From: Sue Howell
Sent: 04 March 2019 15:08
To: Planning.Responses
Cc: Anita Gardner
Subject: FW: Planning Consultation on: K/40/18/PL

Comment from Greenspace

Site Address: Spring Tide Gorse Avenue East Preston BN16
1SF

Description of Works: Demolition of existing dwelling & erection of 1 No. dwelling, associated landscaping & parking (resubmission following K/11/16/PL).

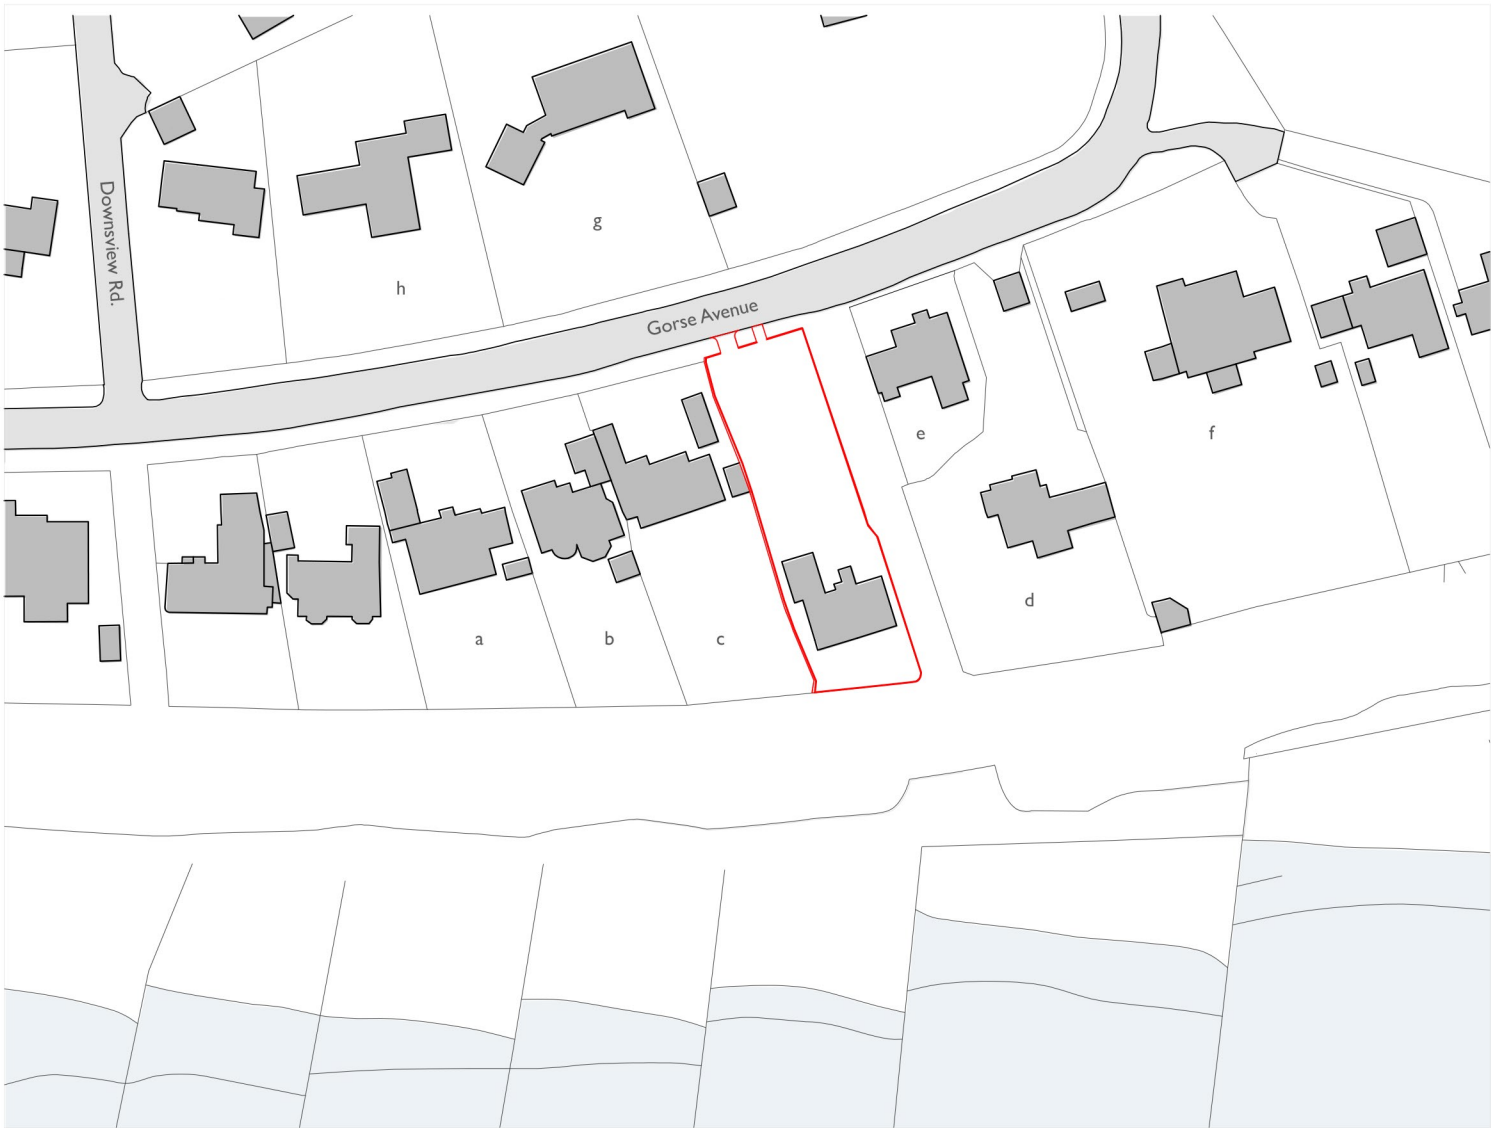
Detail should be sought from the applicant re existing vegetation on the site and details for their protection and retention. Further landscape details should be provided in plan form regarding species choice, quantities, size at time of planting and planting densities of new planting proposals, these are required to ensure that the development proposals can be seen in context to its surrounds and that they are fitting for location.

I would recommend that the above is requested or conditioned with any decision.
